FROM: Jodie Wilkes

SUBJECT: A/149/17/A- 1No. new totem sign and 2No. new freestanding rectangular signs to site entrance.

Rustington Golf Centre, Golfers Lane, Angmering, West Sussex, BN16 4NB

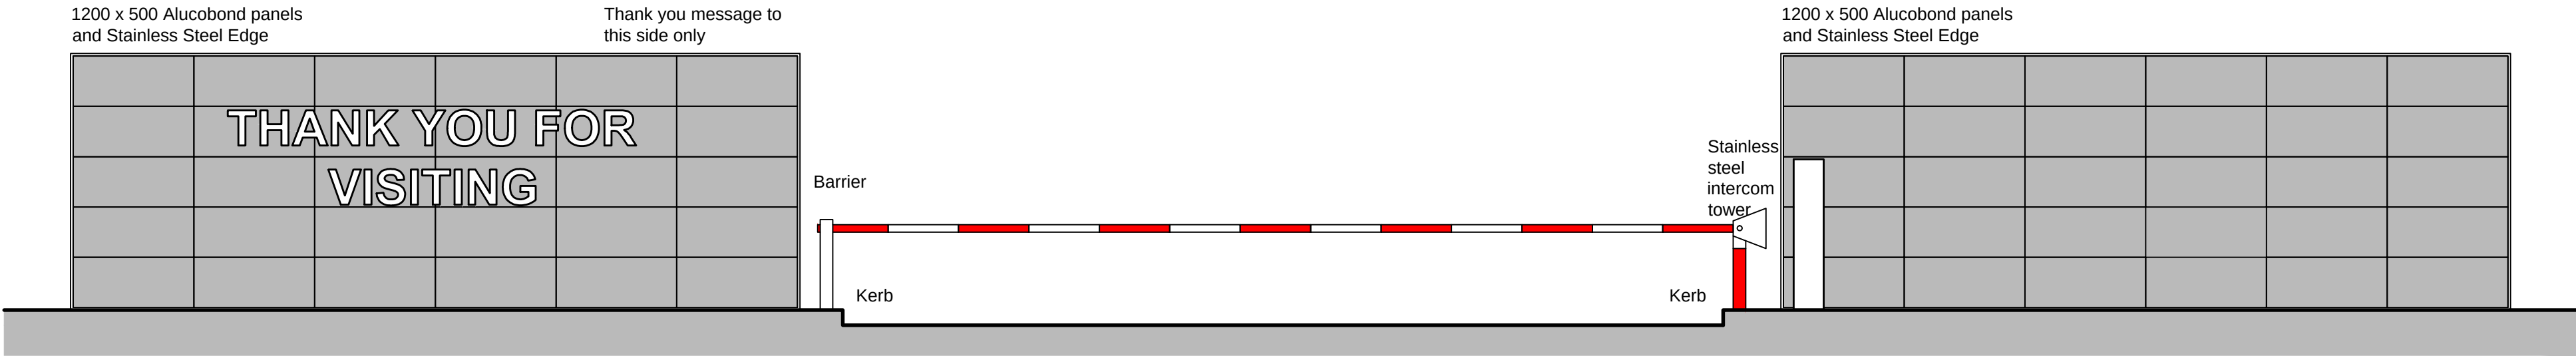
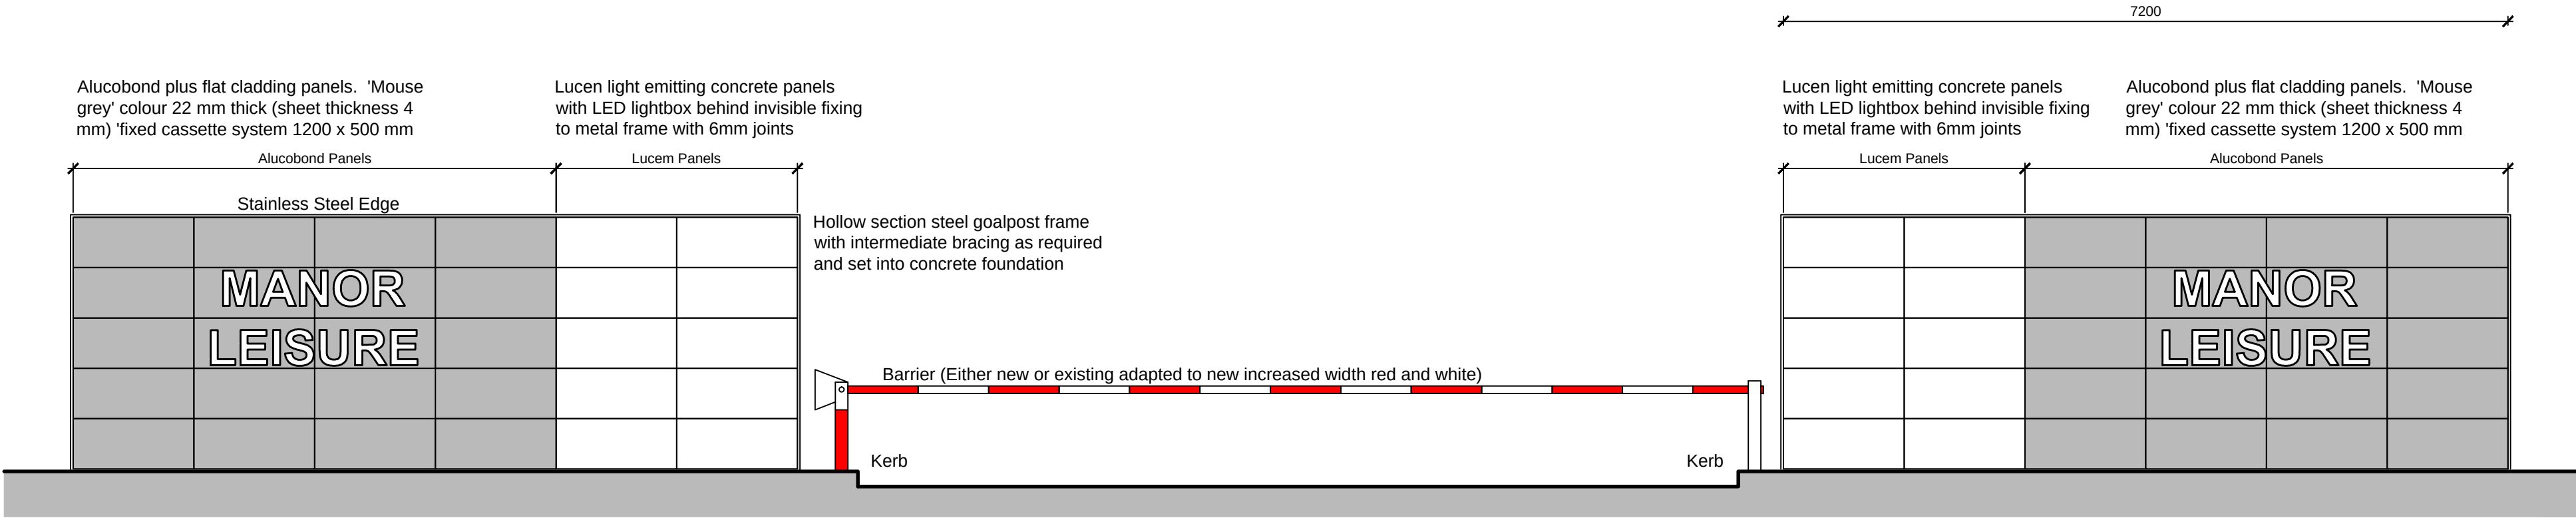
The proposed rectangular signage is a replacement of existing signage and would not be anticipated to cause a safety concern.

Title
Site Entrance Totem
Sign AS PROPOSED

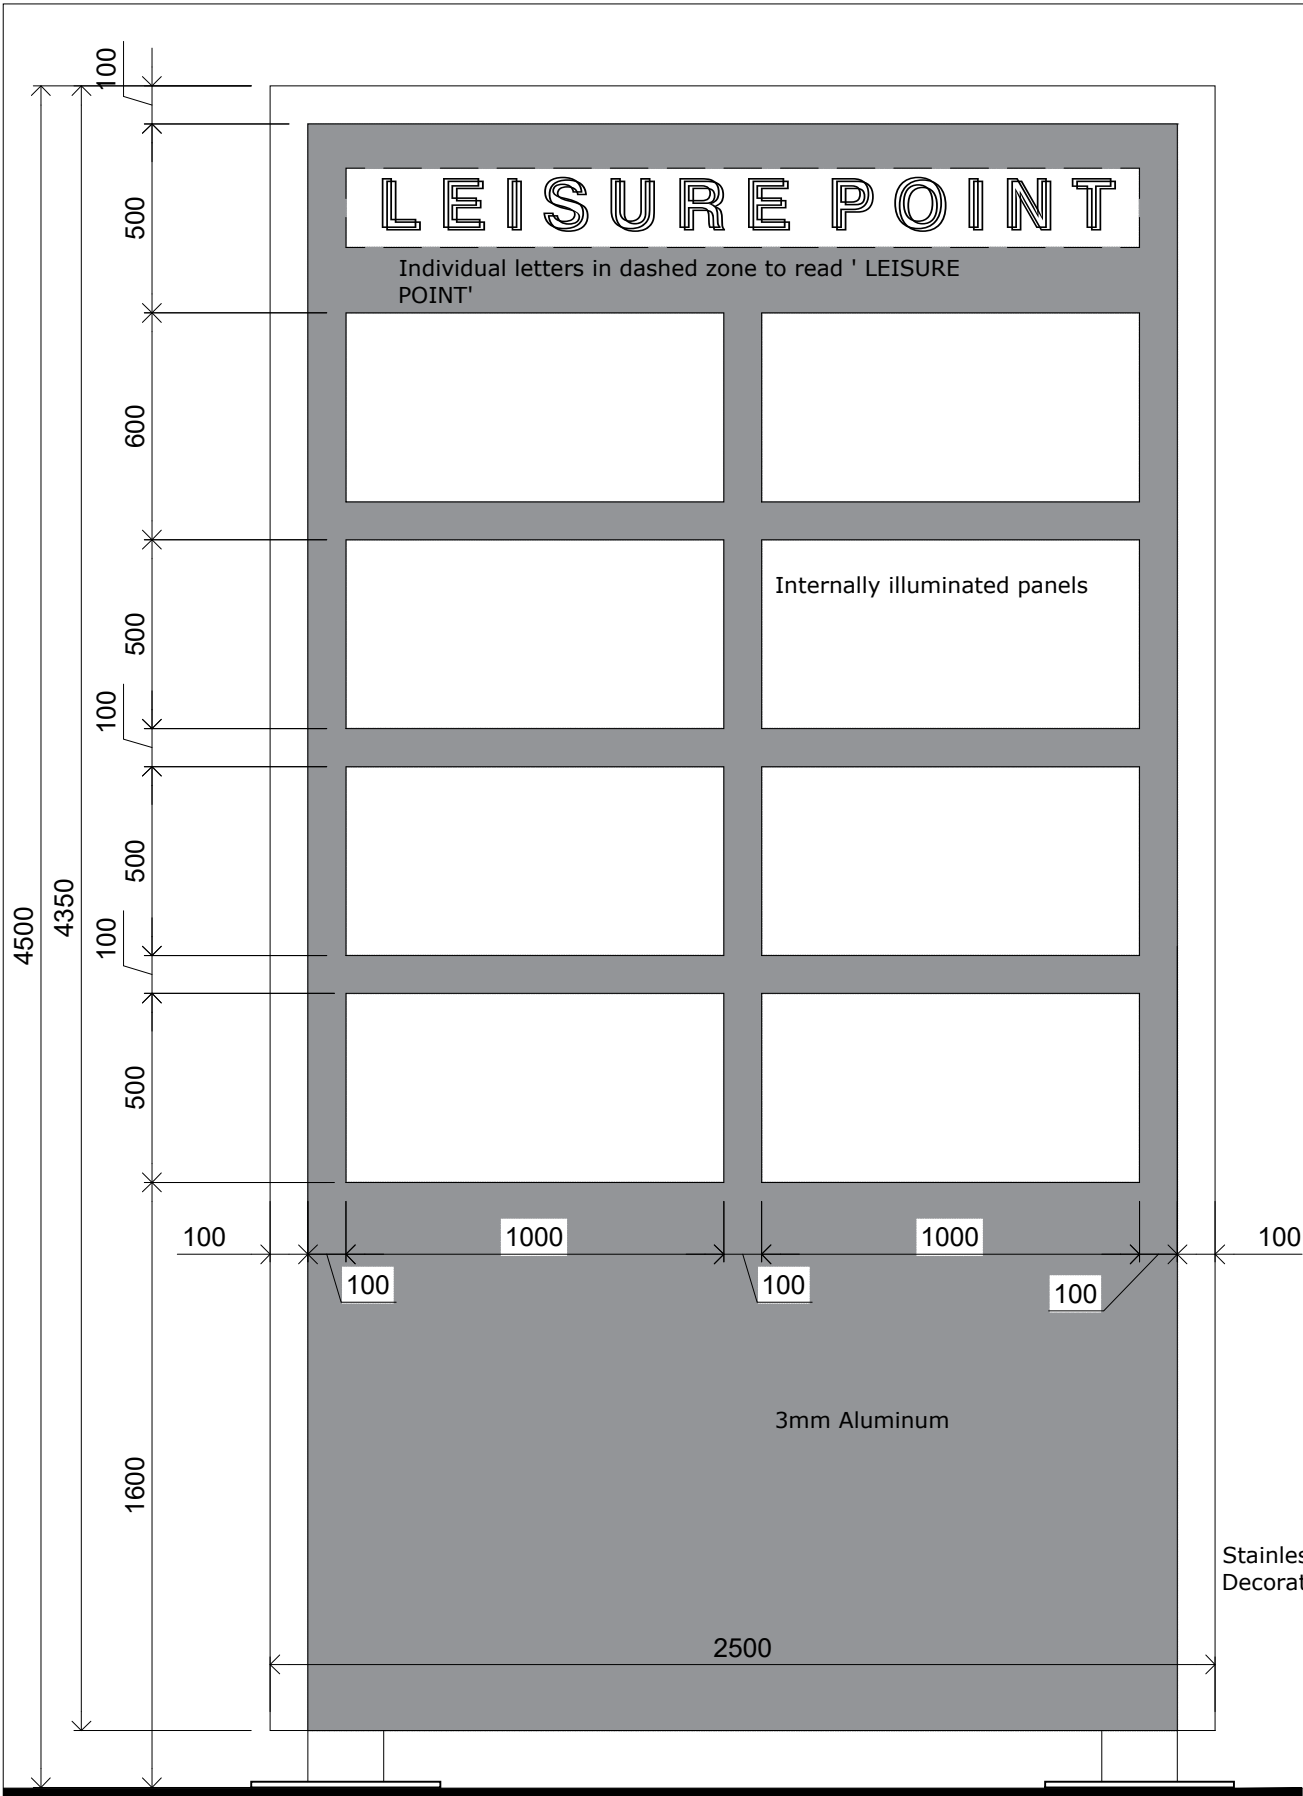
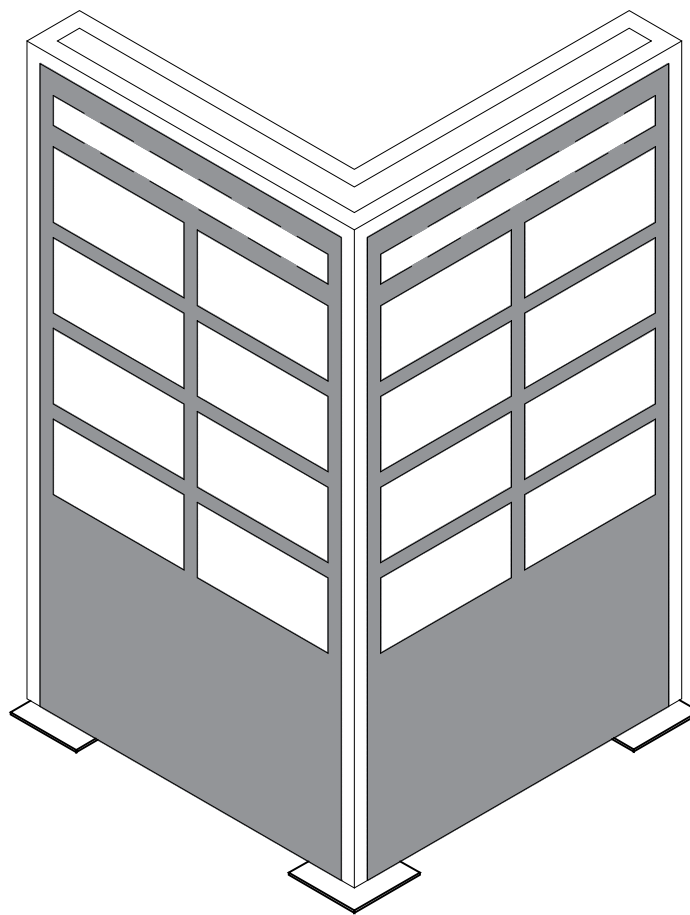
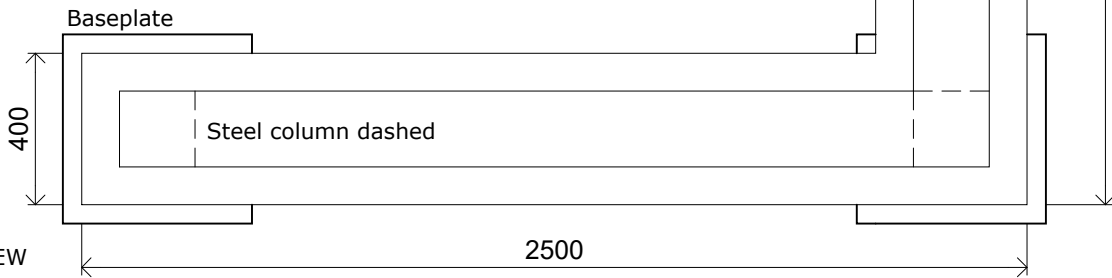
The LHA has previously been consulted on matters at this address under application no A/84/17 to which the LHA offered Advice with no objections. This sought permission for a new retail unit with mezzanine together with associated car parking and service road. The most recent proposal seeks to amend the totem advert design at the front of the site. The dimensions of each face of the monolith sign have been amended to 2.500mm(L) x 4500mm (H) x 400mm(W) Previously the sign measured 2400mm (L) x 9300mm(H) x 652mm(W). The proposed alterations seek a reduction in height with the sign becoming 100mm wider; this would not be a material change over the previously approved signage.

The sign is located outside of the Publicly Maintained Highway and does not obstruct visibility for vehicles exiting the site.

The proposal states that the illuminated signage will be lit to a maximum of 800cdm². This figure exceeds levels outlined within The Institute of Lighting Engineers' Technical Report Number 5: Brightness of Illuminated Advertisements (2001). This outlines that in this location lighting should not exceed 300cdm² and therefore a condition securing this is also advised and worded below. This is to ensure the safety of road users and to prevent the obscuring of or hindering the ready interpretation of any road traffic sign and to retain achievable sightlines for users of both Rustington Golf Centre and the adjacent highway.

The luminance of any permitted advertisement may not exceed the limits outlined within The Institute of Lighting Engineers' Technical Report Number 5: Brightness of Illuminated Advertisements (2001) specifically for the Angmering Area. This required maximum luminance level is 300cdm²; Illumination is not permitted on the above signage unless the advertisement meets these requirements.
